Attached is our response to the documentation received related to the Aspect Industrial Estate Development Application at 804 Mamre Road (SSD-10448). We trust that this information will help inform Mirvac's response to Western Sydney Airport on the matter relating to the following comment:

**Wildlife Hazards – Vegetated Areas**

**Wildlife Hazards – Fill:**

Drawing Name:
Landscape Plan
Stage 1 Masterplan

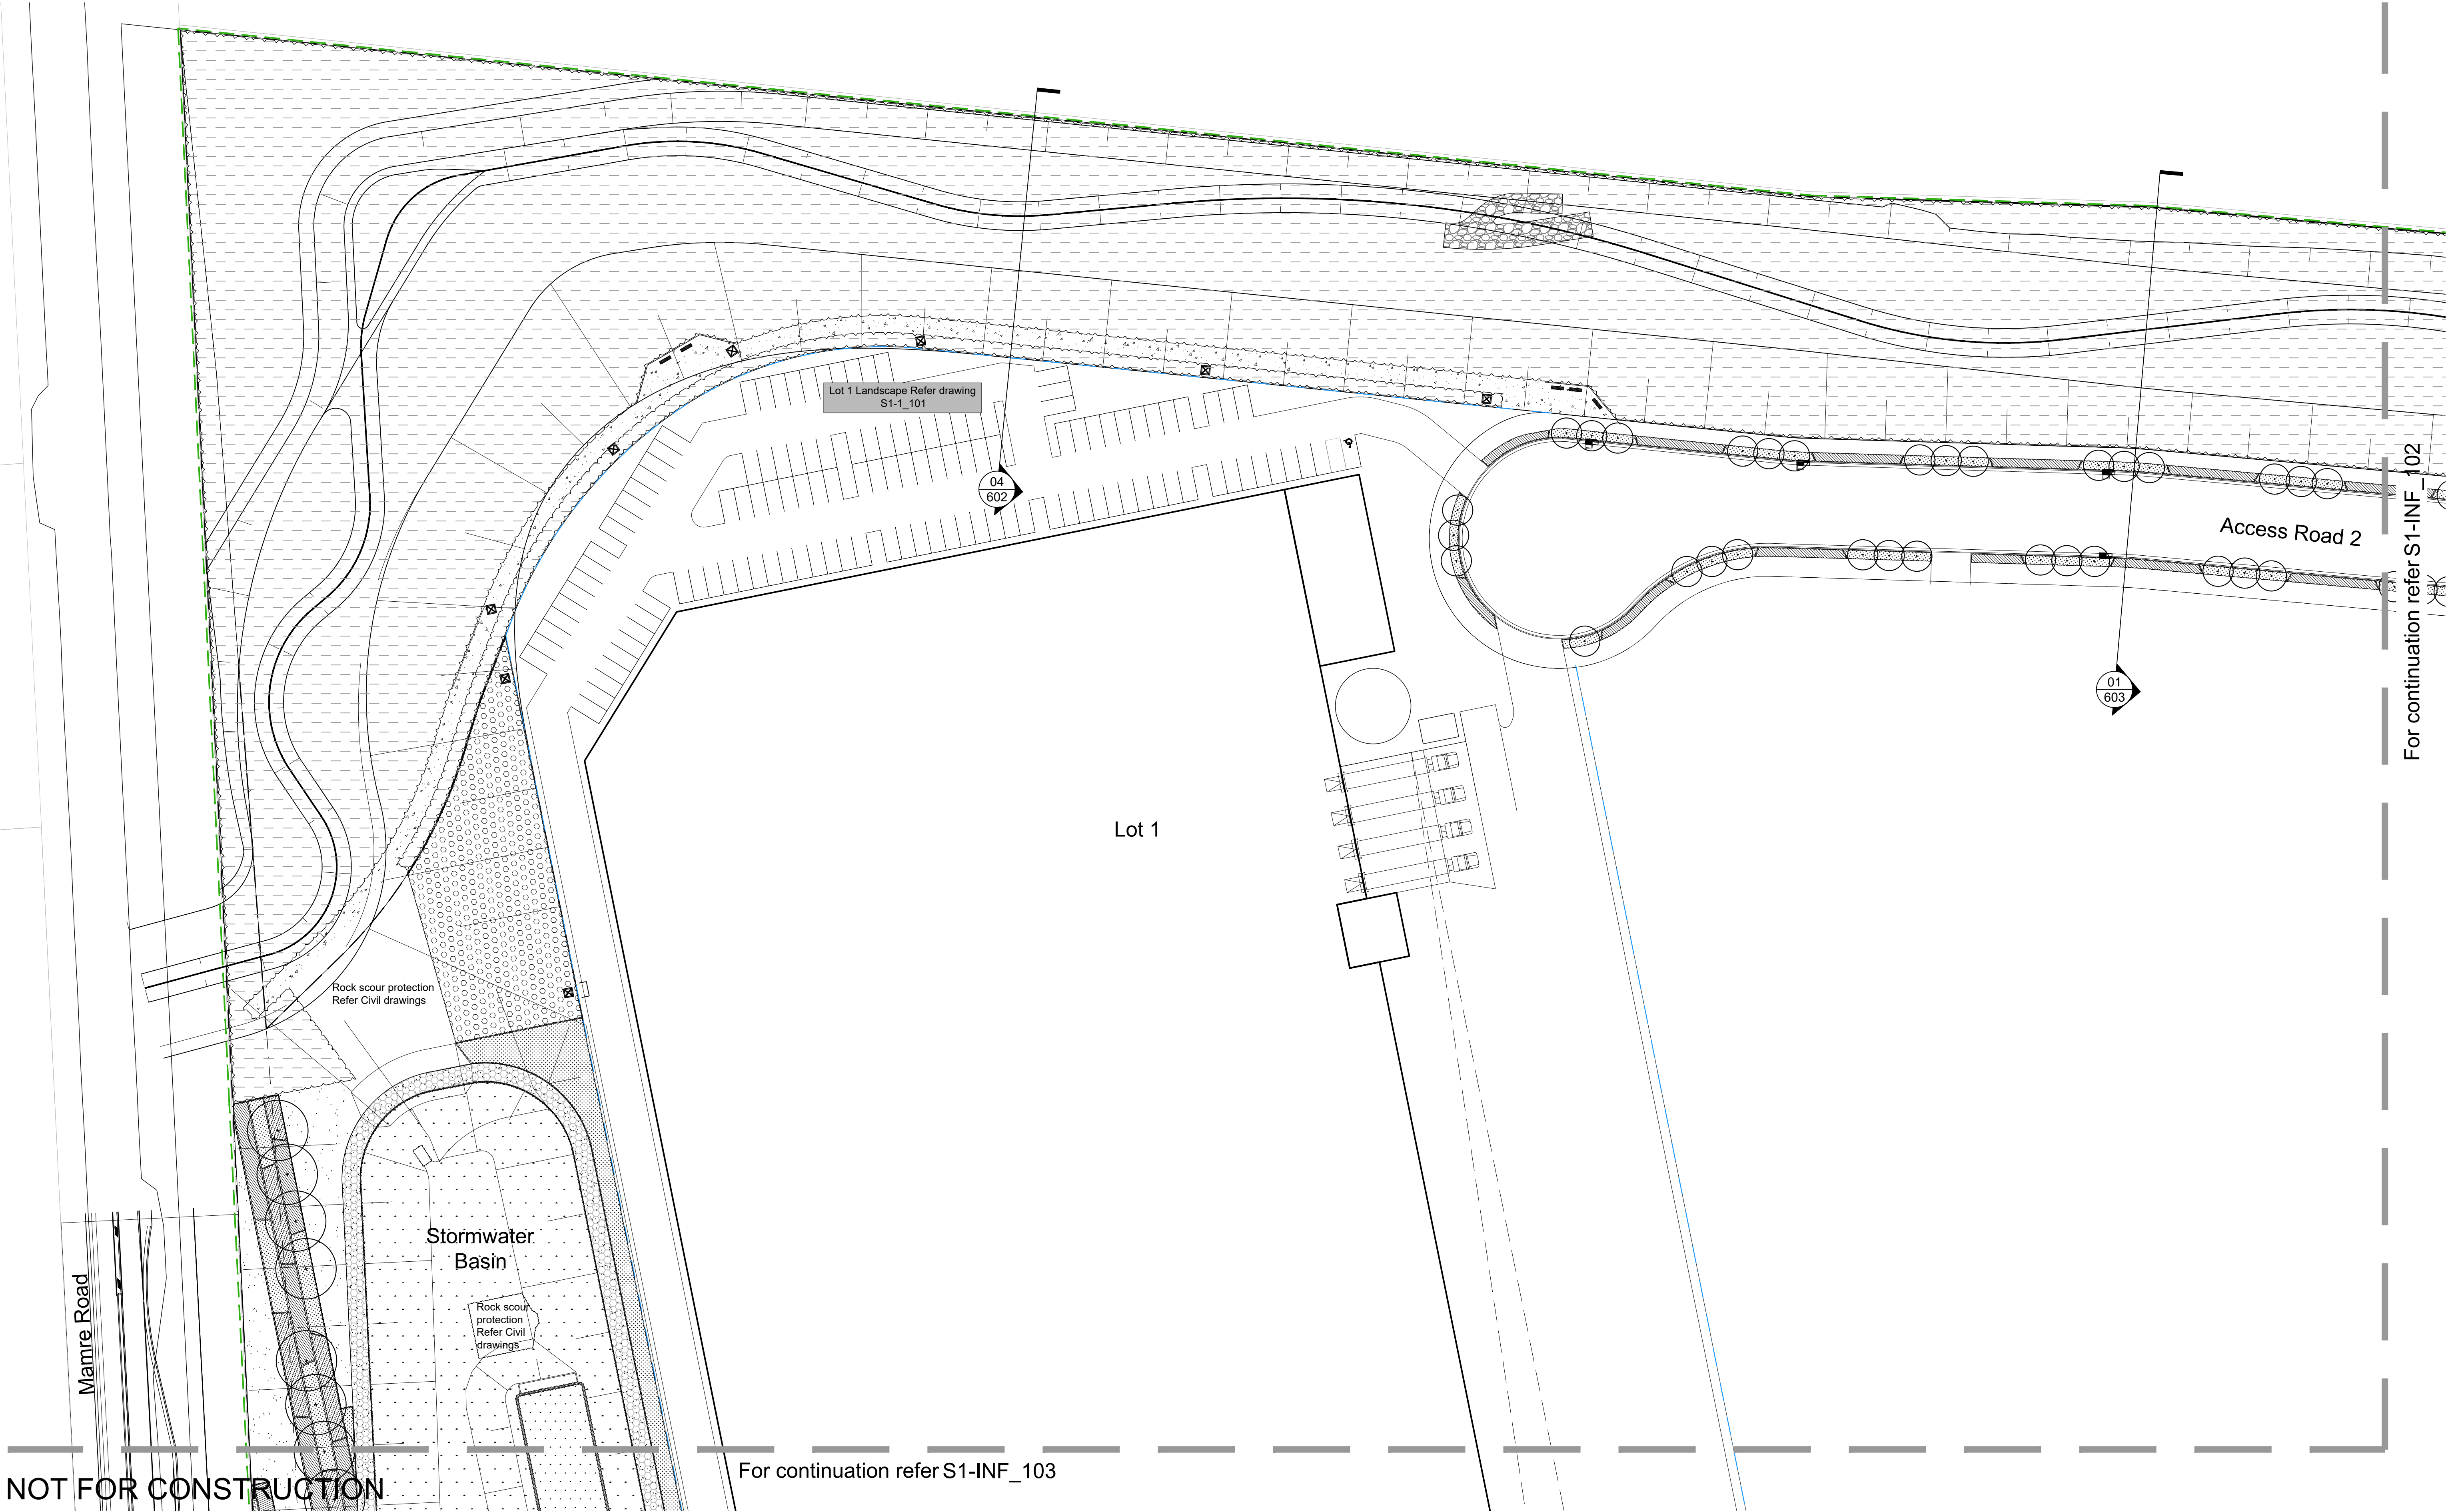
The proposal includes the realignment of an environmental corridor along the northern boundary of the site, and the provision of a riparian zone, including plating along the realigned corridor. The proposal also includes the provision of a stormwater basin on site. It should be ensured that this wildlife zone does not present an increased risk of wildlife attraction in relation to the future airport. The Aeronautical Impact Assessment that forms part of the DA package does not address the risk posed by these factors. Landscaping species should be selected to deter the attraction of birds/flying foxes.

Mirvac will review the landscape species to be used against the landscaping species

guidelines established by the Western Sydney Planning Partnership (yet to be released) and the principles detailed in the Aerotropolis planning framework and modify landscaping to minimise attraction to birds/flying-foxes.

Mirvac will ensure permanent waterbodies will incorporate appropriate mitigation options detailed in Draft Western Sydney Aerotropolis Wildlife Management Assessment Report.
